Thomas FitzGerald - Online Submission from Thomas Mark Upton of Private (comments)

I make the following comments for your consideration:

1. Traffic and Zoning

BROADWATER PARKWAY
LAYOUT

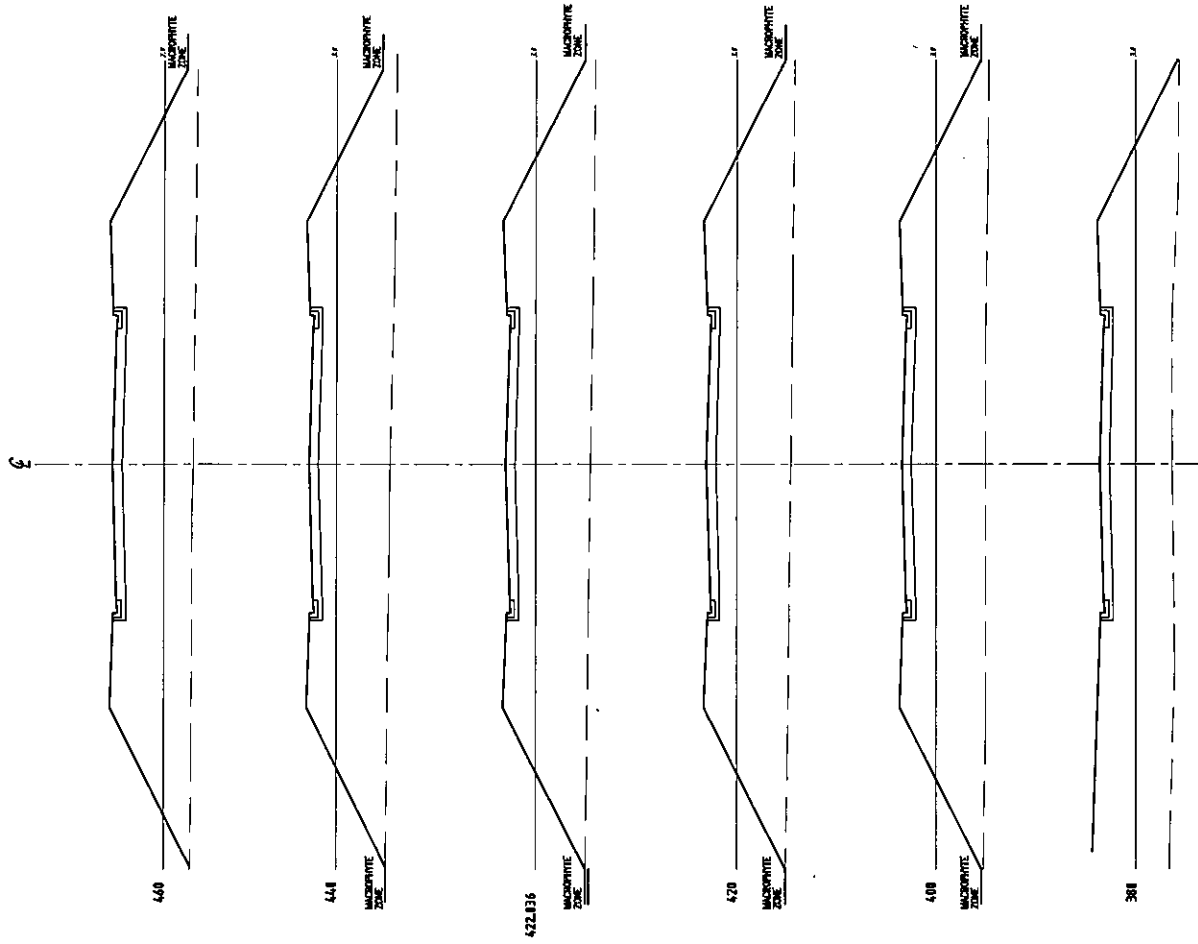
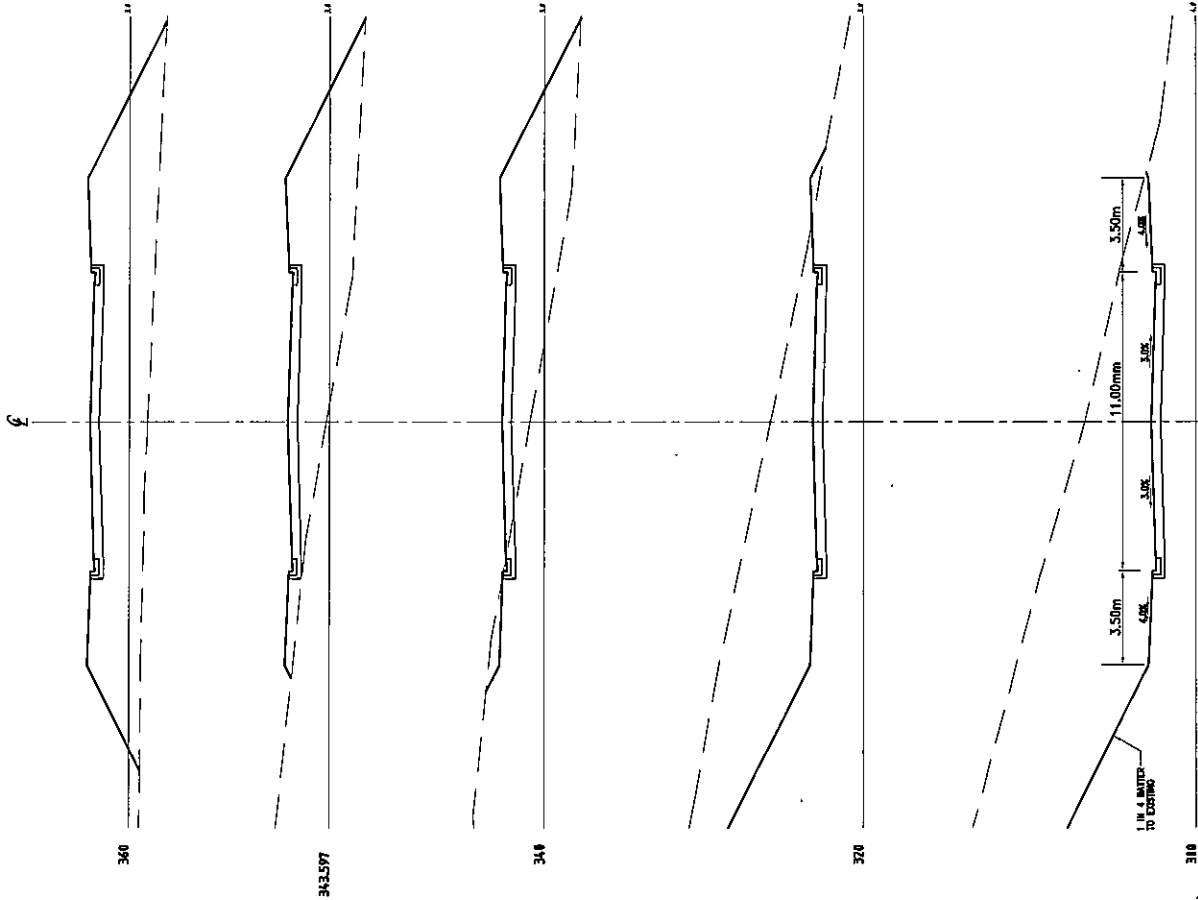
(b) The temporary intersection proposal is unacceptable. It would seem the proponent cannot undertake construction of the Broadwater Parkway in the first stage of development due to not owning the land. It would be reasonable to ensure this roadway, being the main access for the entire subdivision and vital to limiting traffic to Parkes Lane and Market Pde be redesigned onto land owned currently by the developer. If in time it can be realigned, then so be it. The other foreseeable problems are the financial viability and long term desire of the developer to carry out the later works. What happens if the developer ceases to exist after the first stages, or if Stage 7 doesn
